COMMUNITY SERVICES DEPARTMENT

June 21, 2019

Subject: Walden Preserve 2 Amended PUD Development Plan Filing No. 4A

WALDEN PRESERVE 2, FILING NO. 4  
LOCATED IN THE SW1/4 OF SEC. 14, THE SE1/4 OF SEC. 15, THE NE1/4 OF SEC. 22 & THE  
NW1/4 OF SEC. 23, ALL IN T. 11 S., R. 66 W. OF THE 6th P.M., EL PASO COUNTY, COLORADO

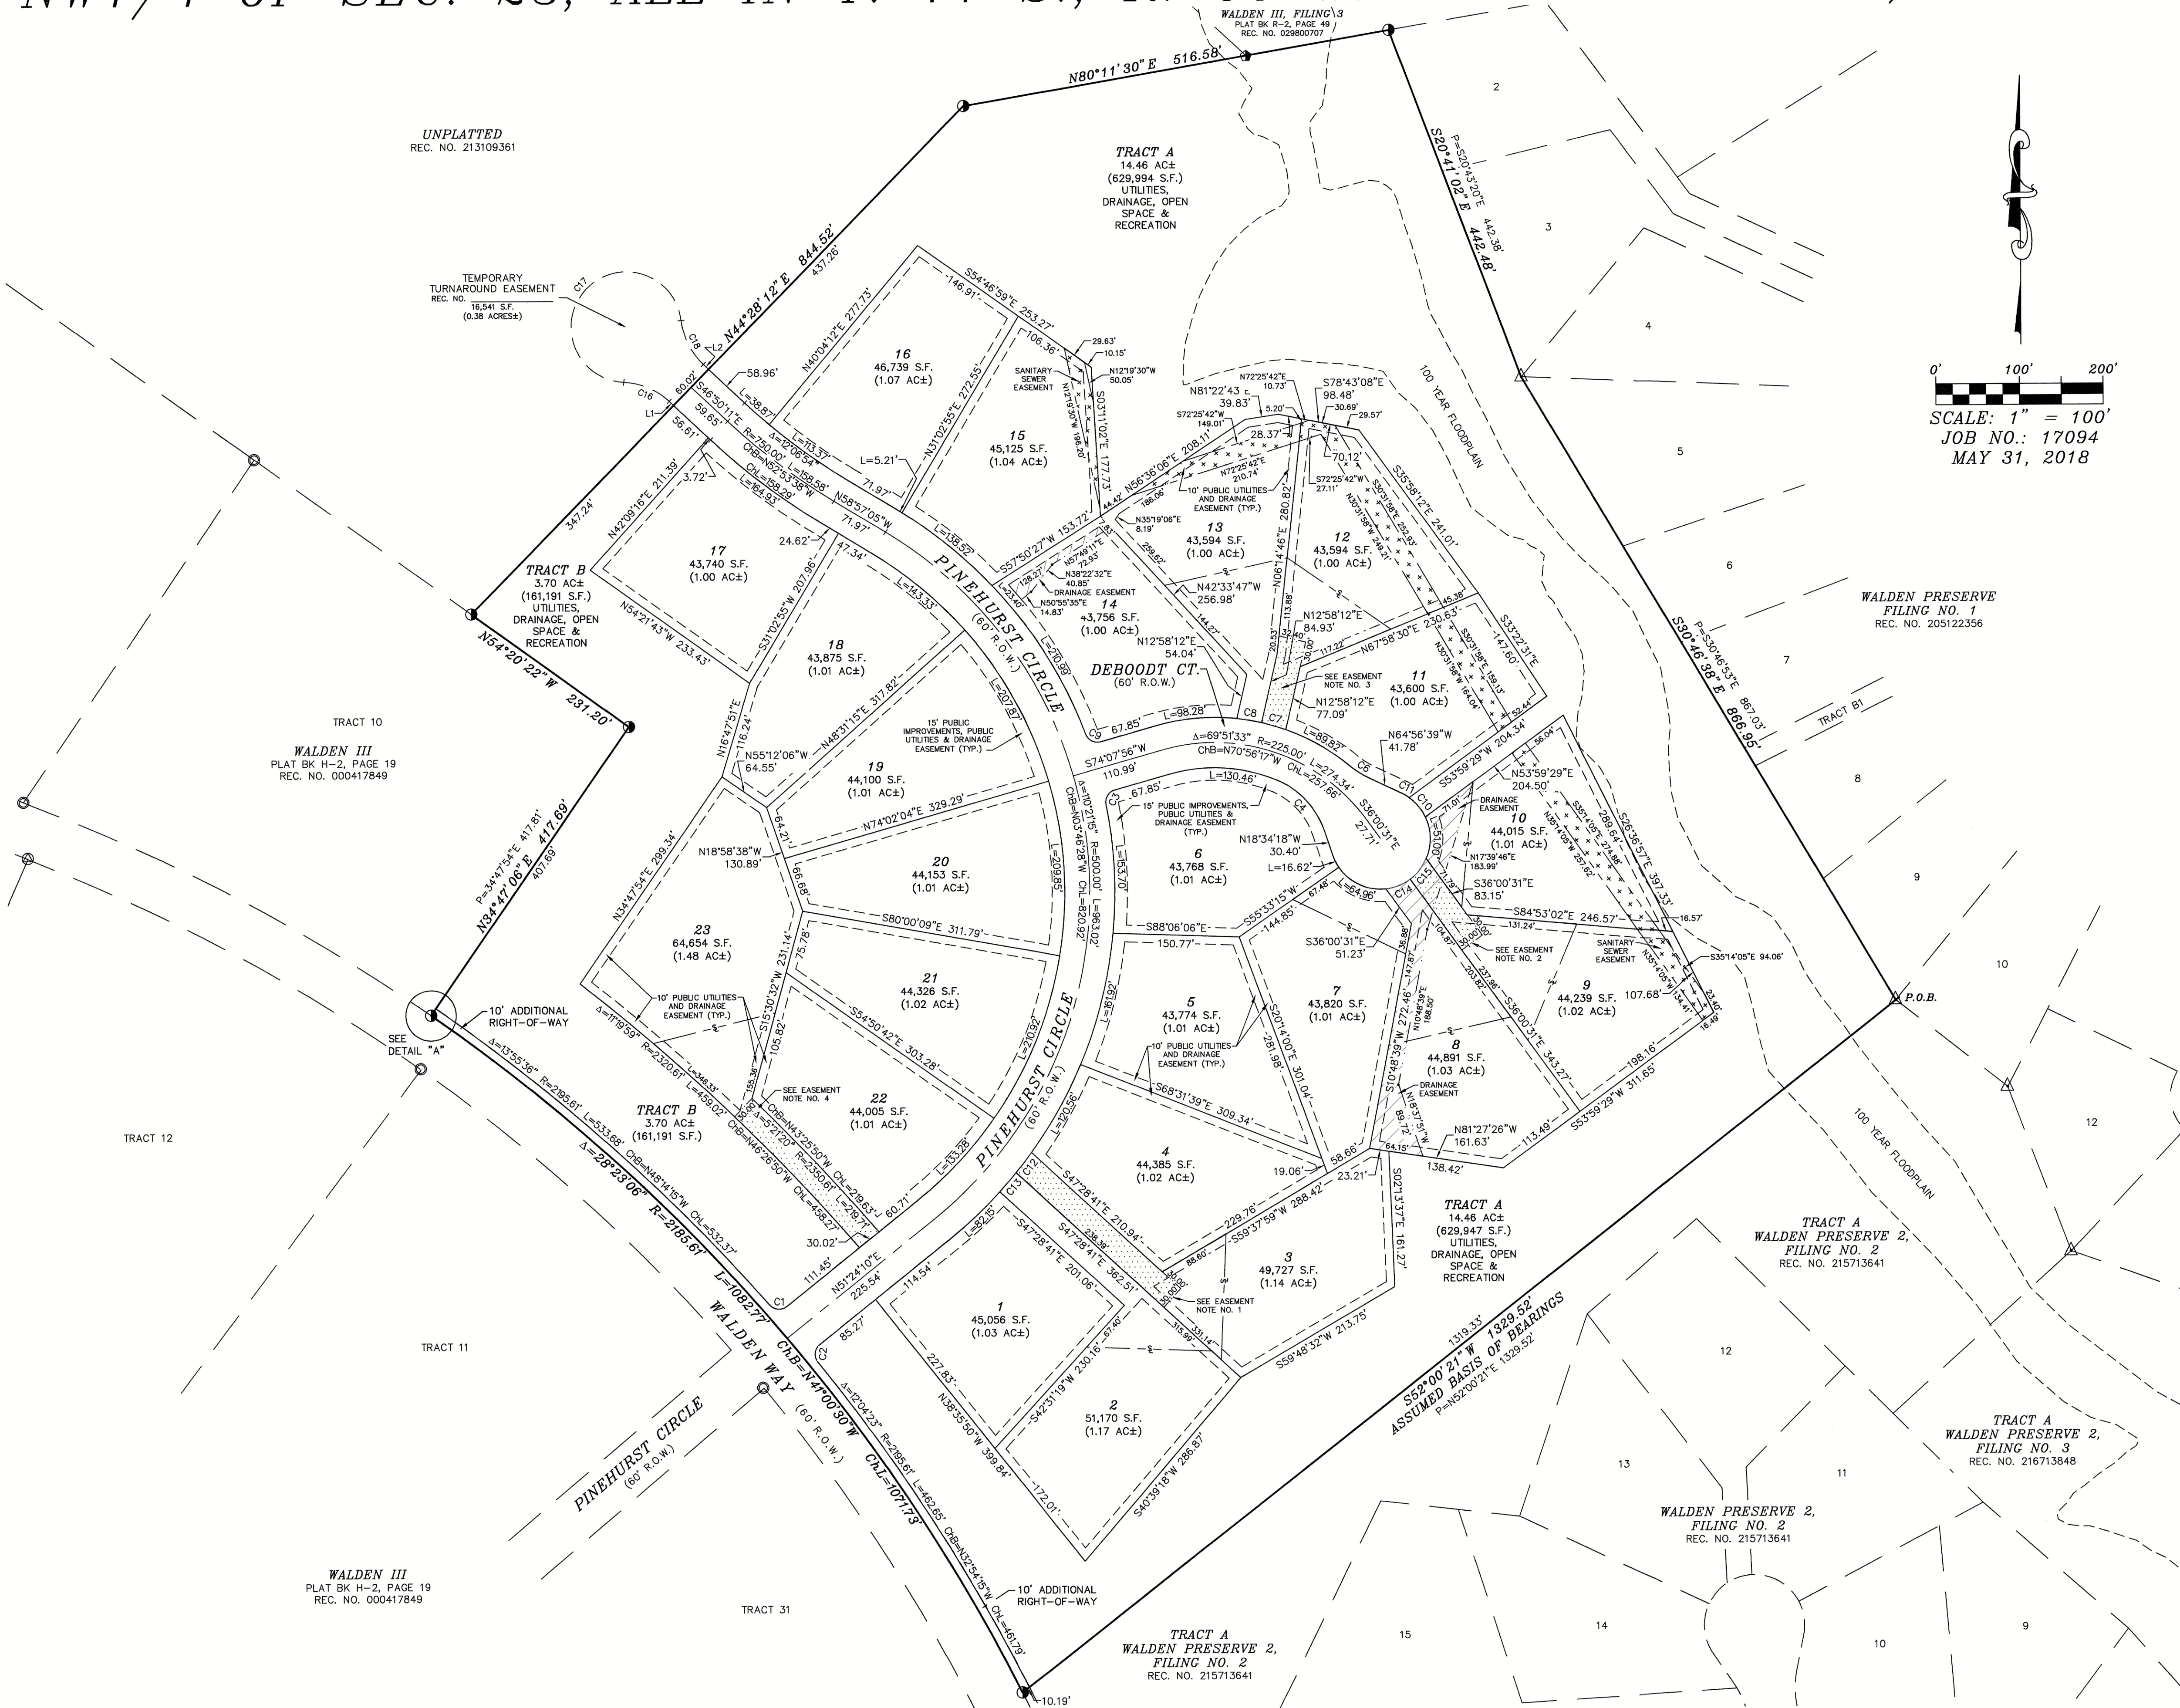
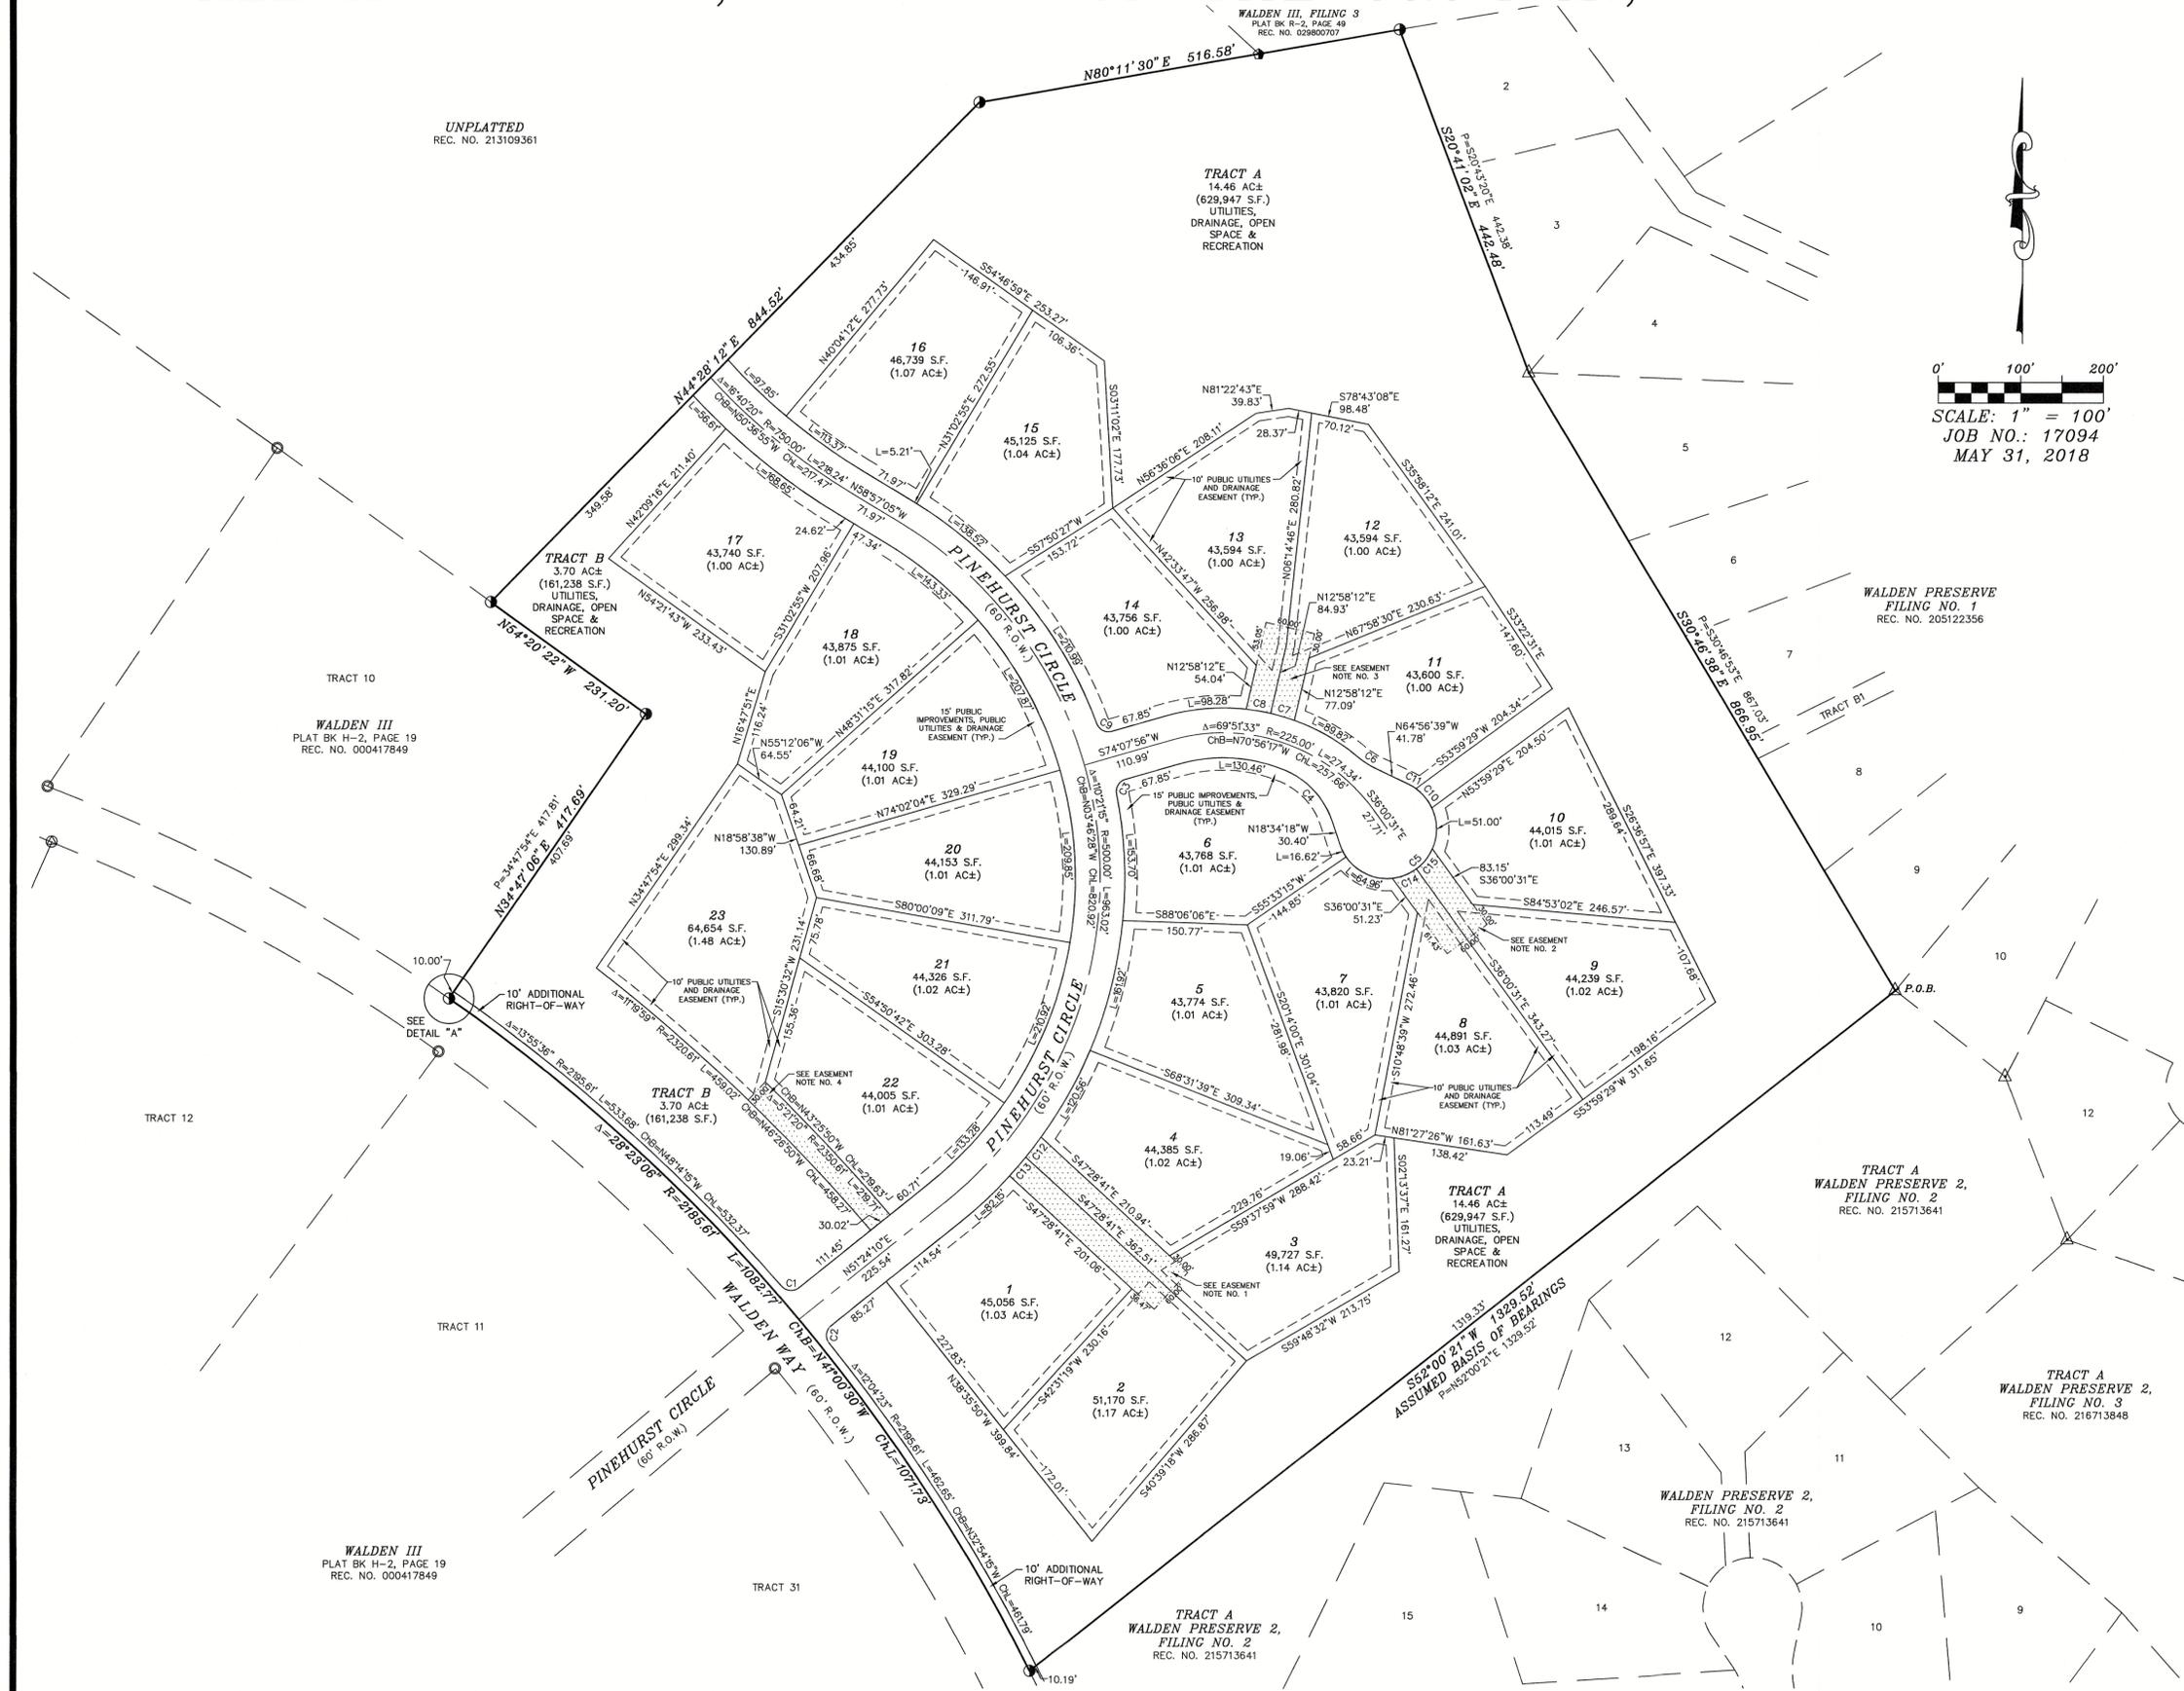
The Cherry Creek Regional Trail is identified on the PUD Development Plan drawings. However the trail is missing from the Filing No. 4 Final Plat drawings that were submitted concurrently with the PUD Development Plan. El Paso County Parks will request this be shown on the final plat drawings.
